Re: Old North State Catering Commissary

Application #1904-003

Harnett County Health Department
Harnett County Environmental Health

ELECTRICAL PLAN
SCALE: 1/4" = 1'-0"

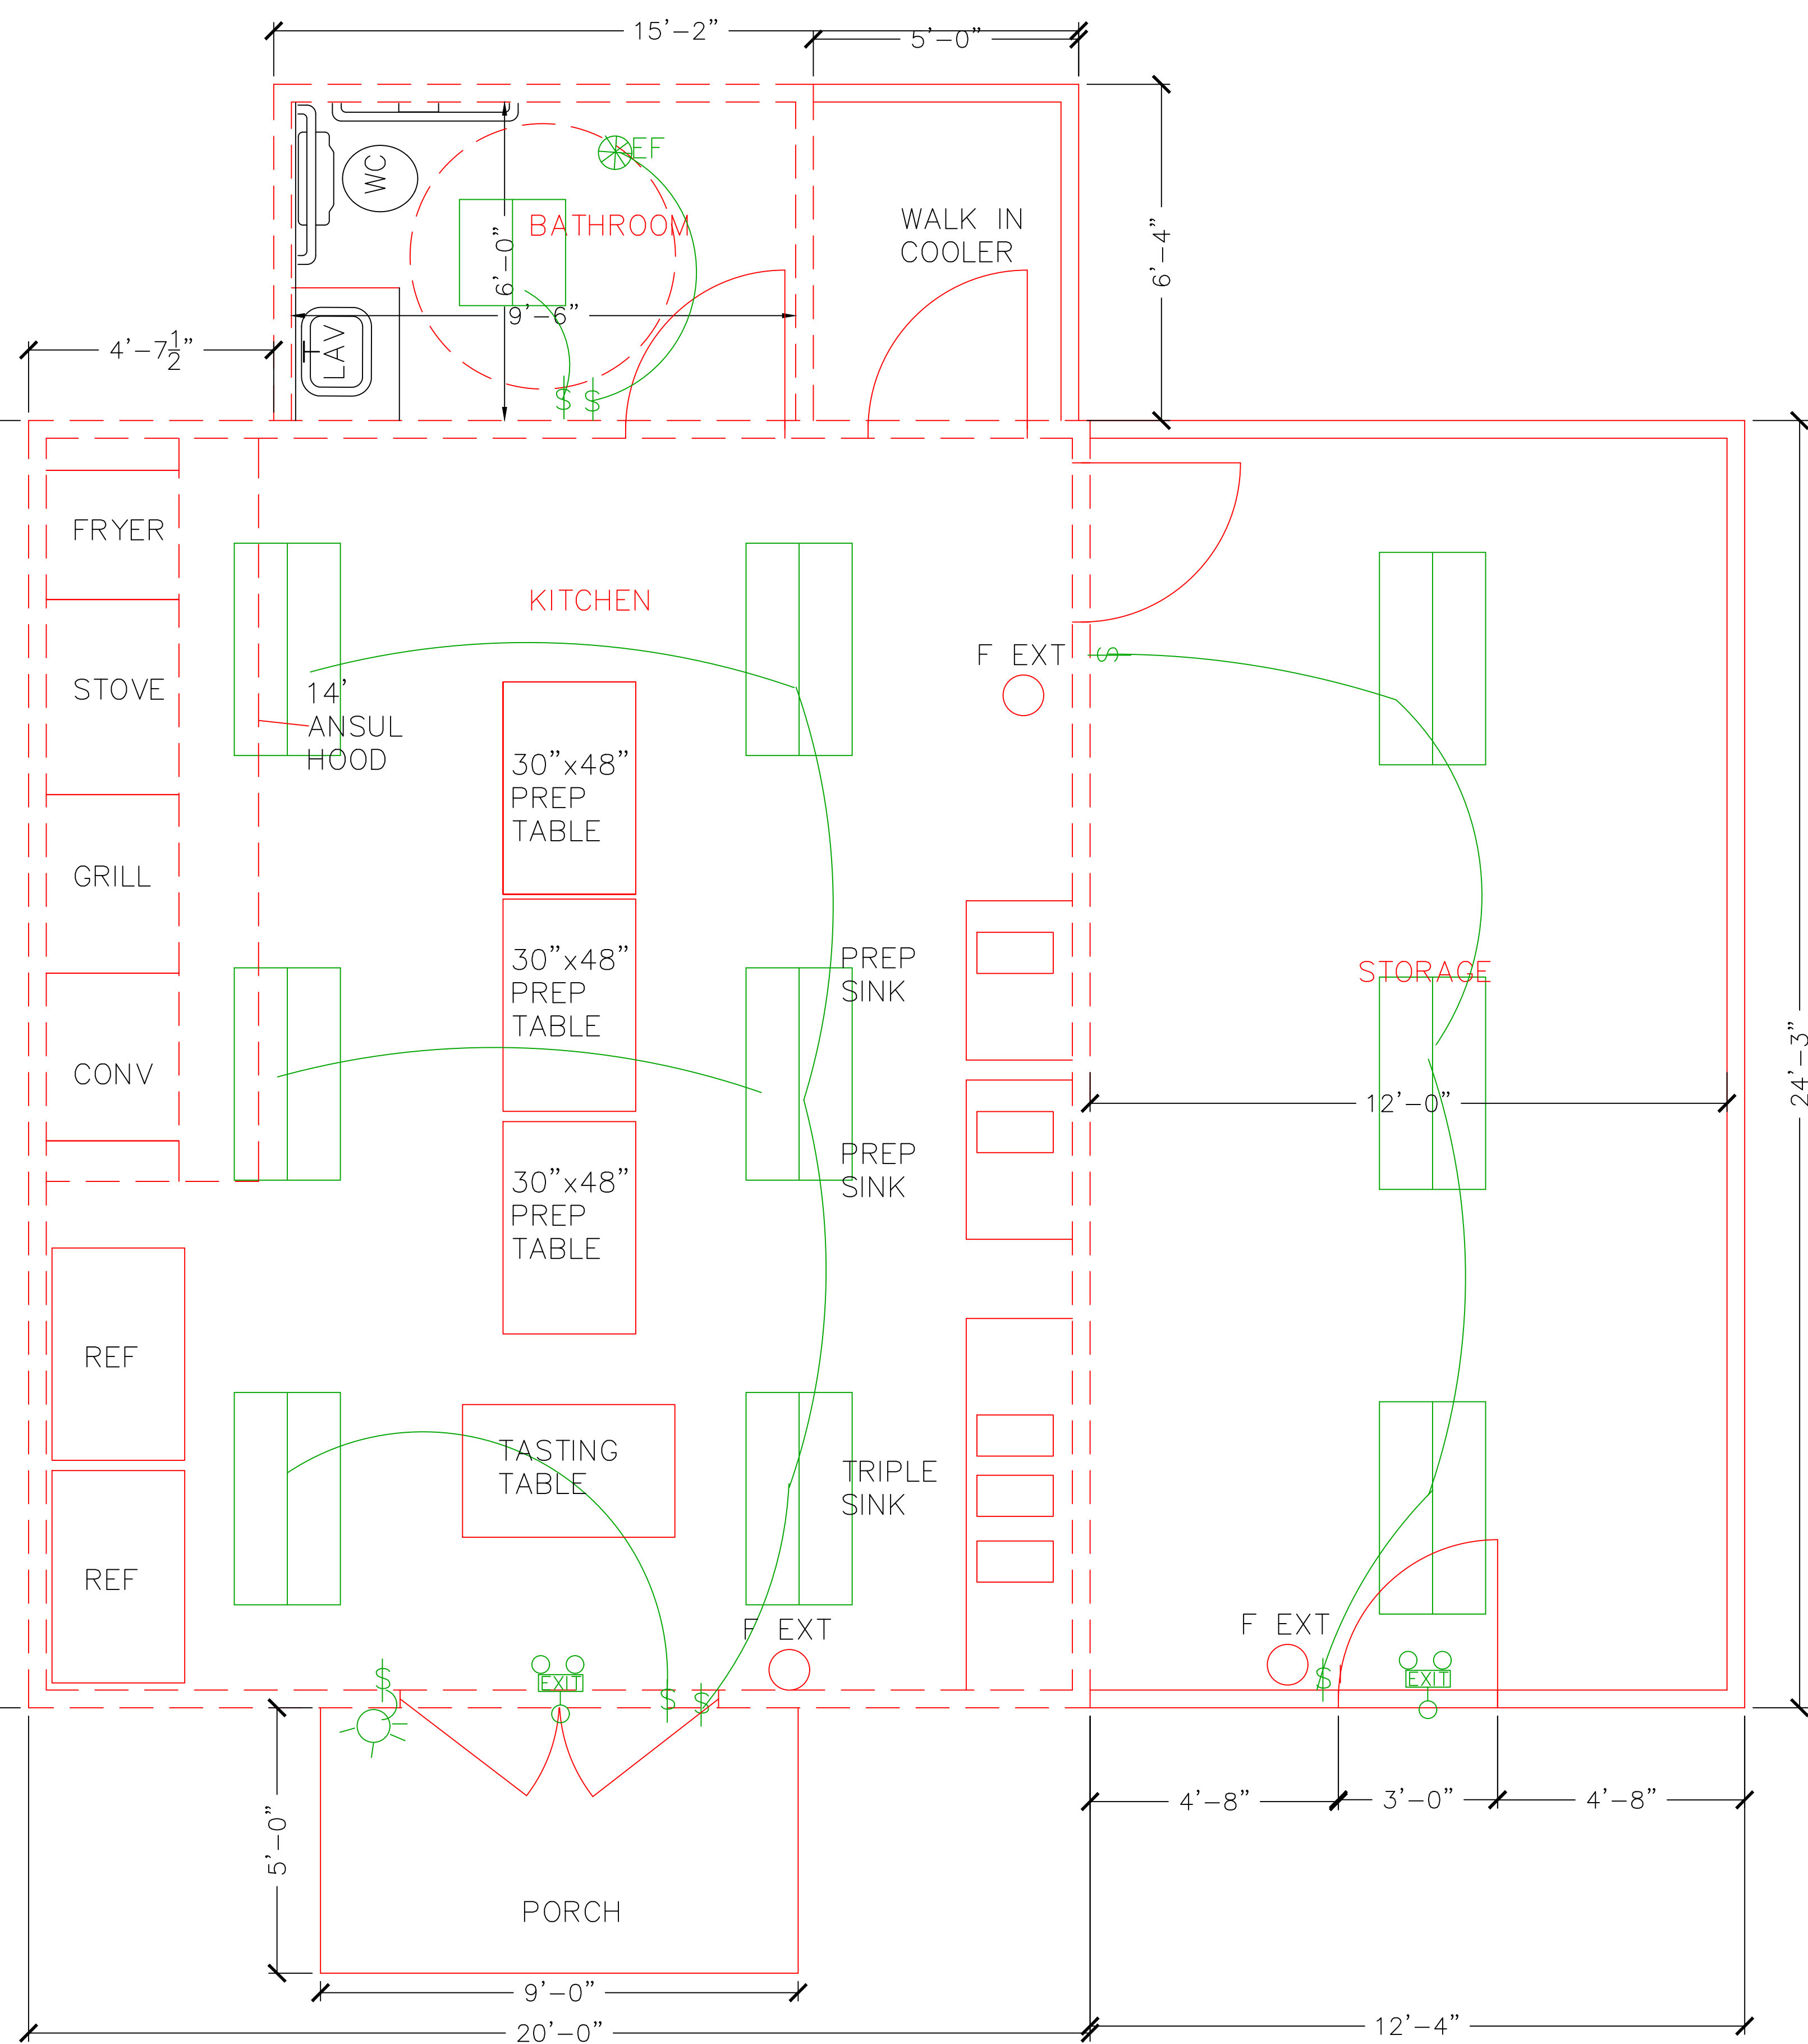
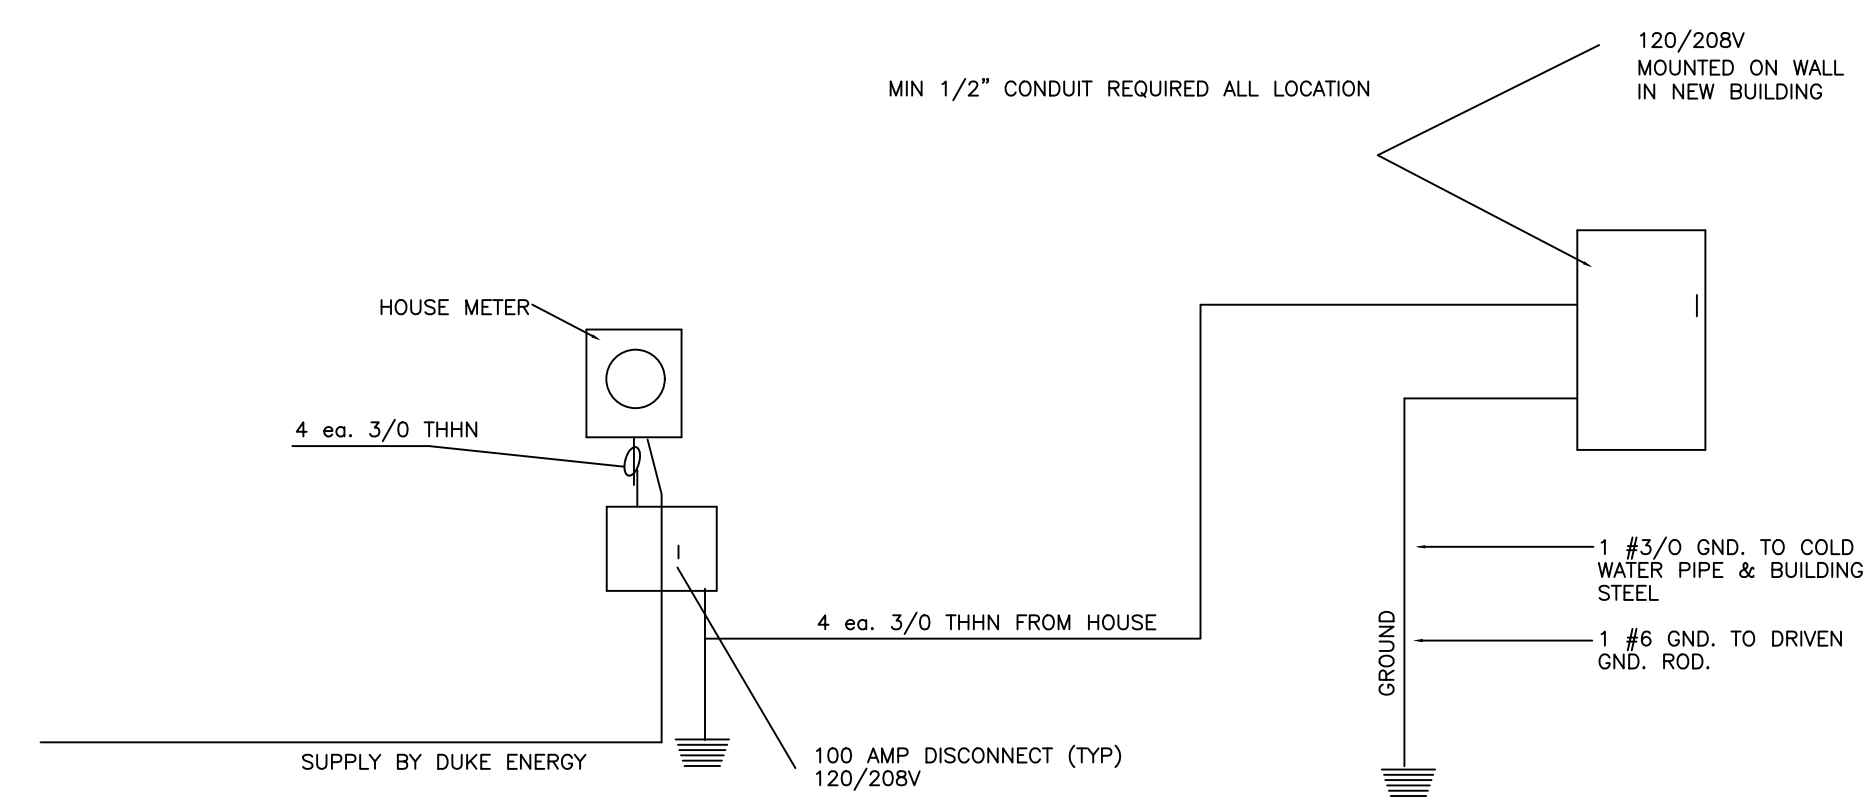
2. Electrical plan-Indicate location of electrical outlets. If tabletop appliances or floor-mounted equipment is used (such as food processors, microwave, blenders, mixers), indicate where equipment is located on floor plan and outlet provided for equipment. Provide equipment specification sheet if not already submitted. Indicate if light fixtures are located under hood. Tankless hot water heater not indicated on electrical plan. Lighting not indicated in walk-in cooler.
